**WEST YORKSHIRE  
POLICE**

**Designing Out Crime Officer**

To: Victor Grayson	Ref: 2019/90467 Date: 2 <sup>nd</sup> April 2019
--------------------	---

**Site Location: Former College buildings, Highfields Centre, New North Road,  
Huddersfield, HD1 5LS**

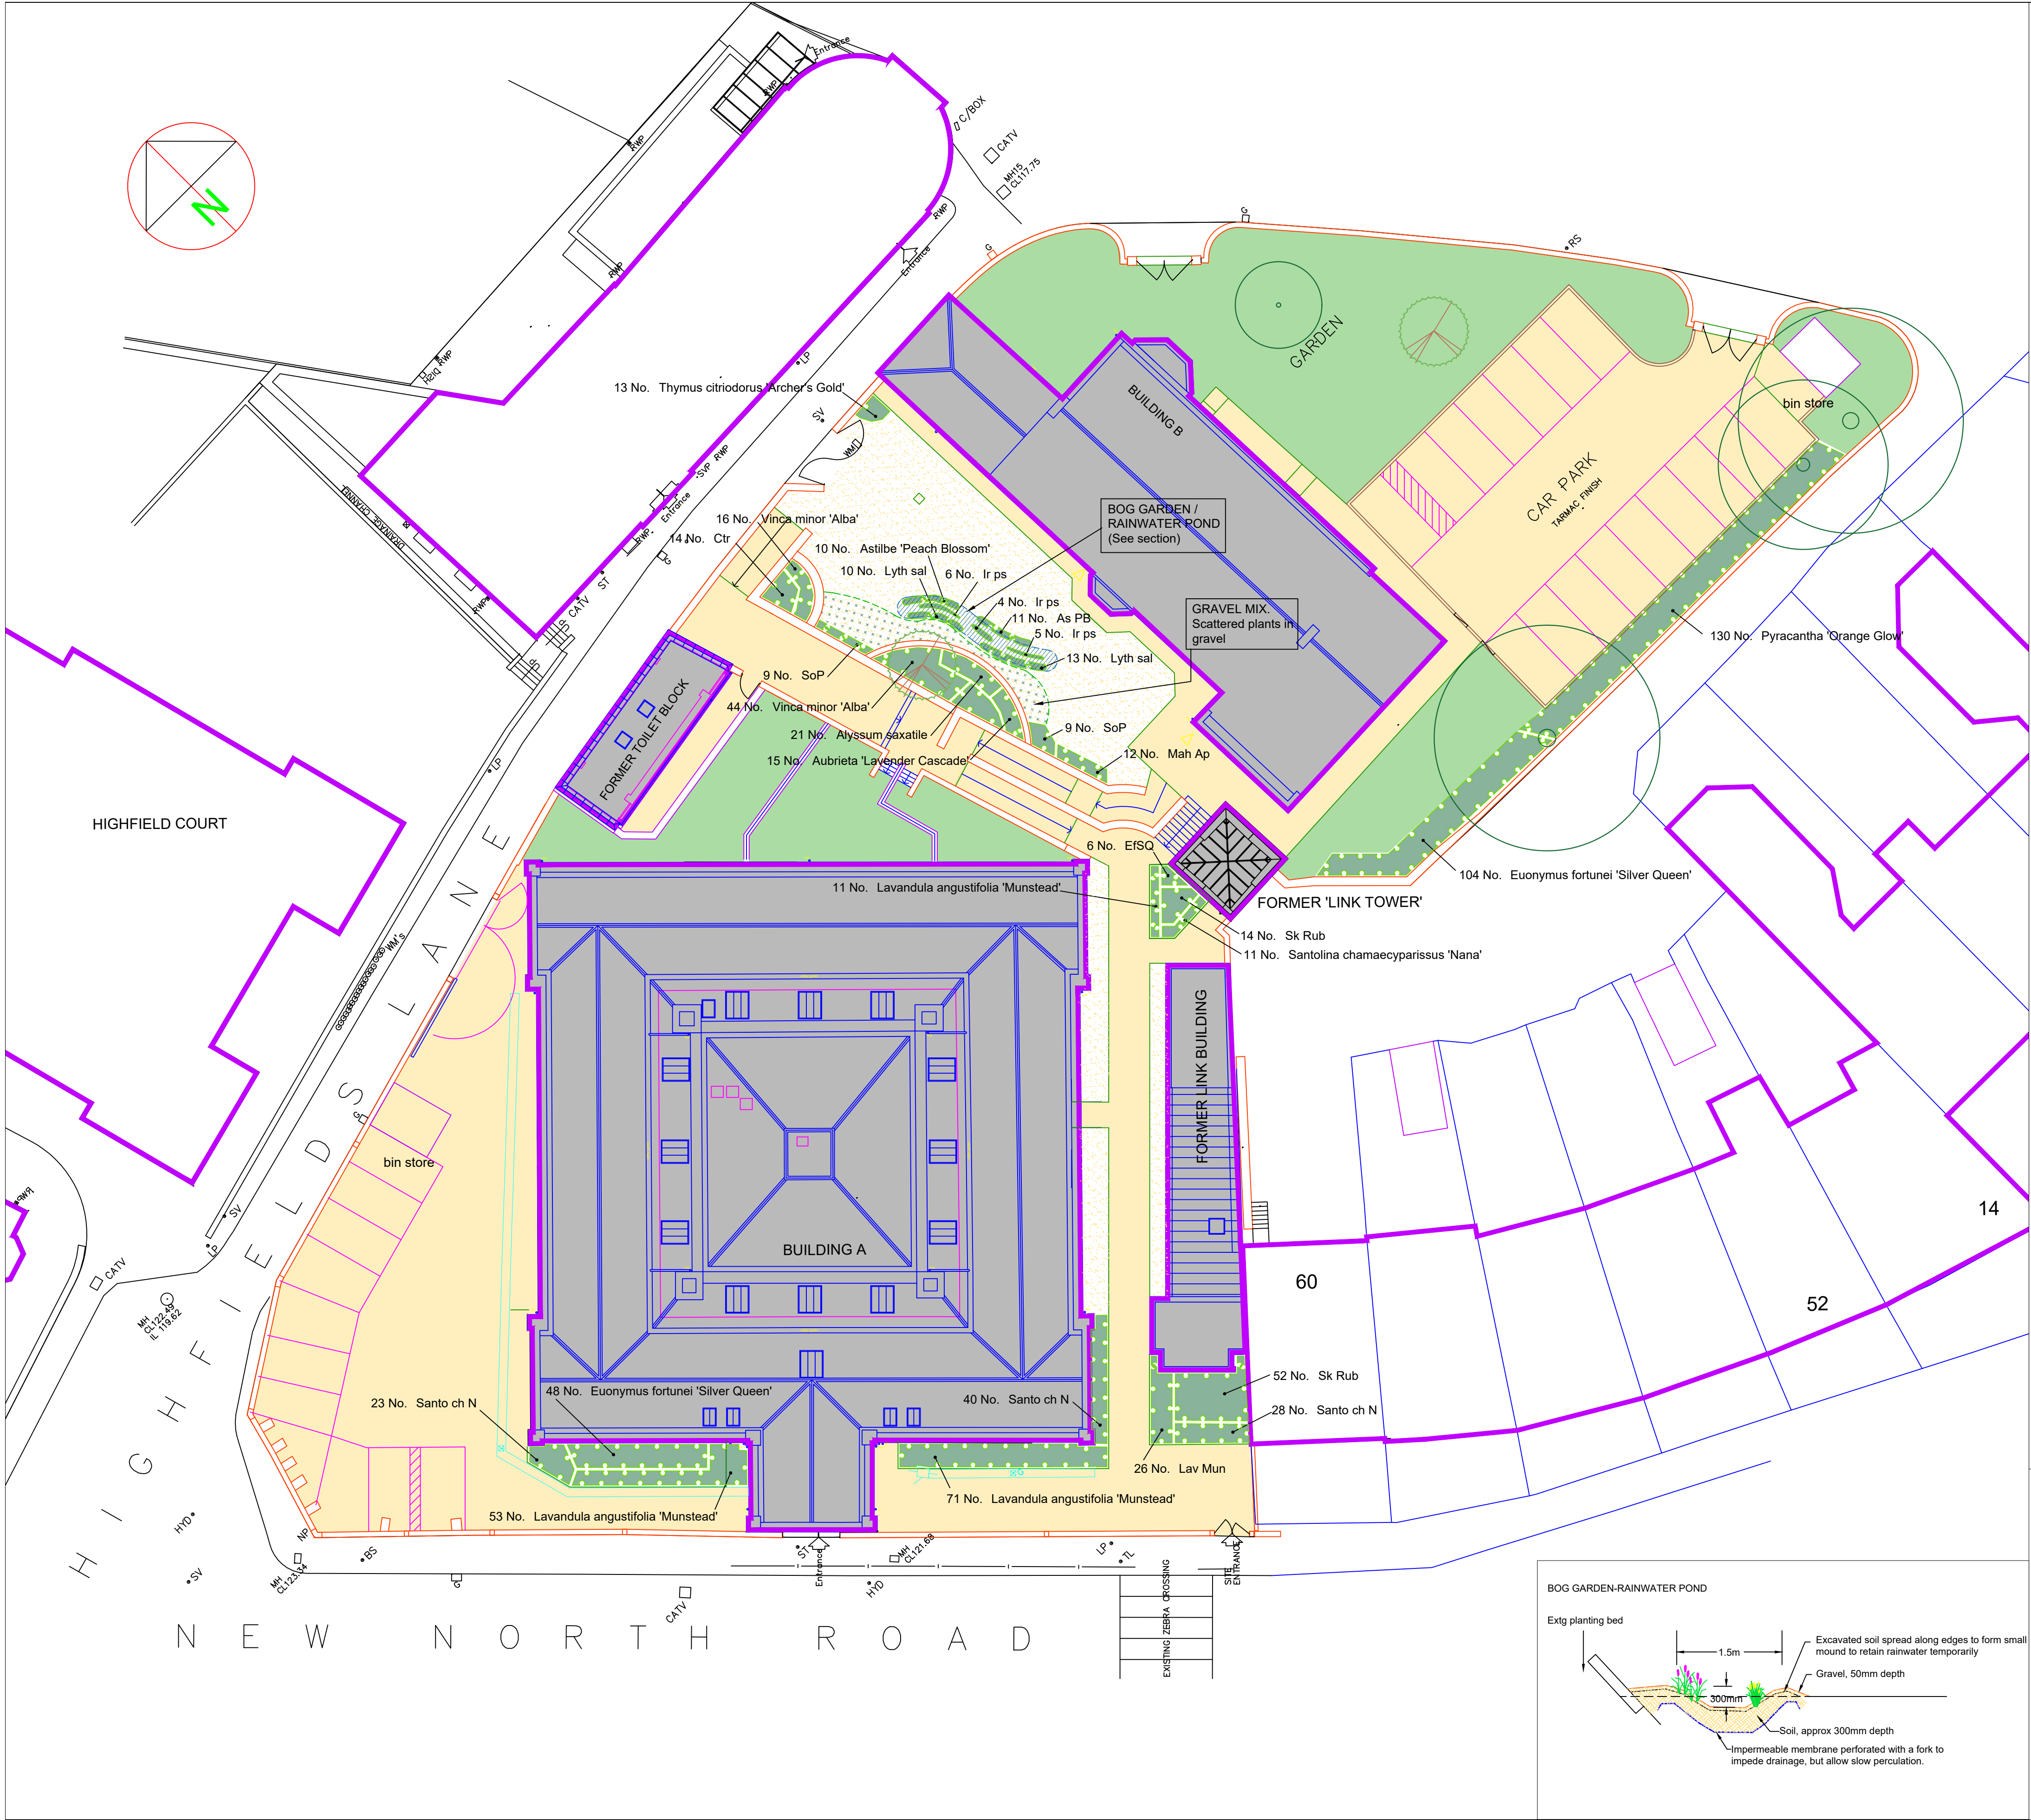
Planting beneath the front main building is mentioned as a buffer zone. I would welcome the planting of hostile plants such as Berberis or Pyracanthus beneath windows on this elevation. This would reduce the climbing access to the windows from outside.
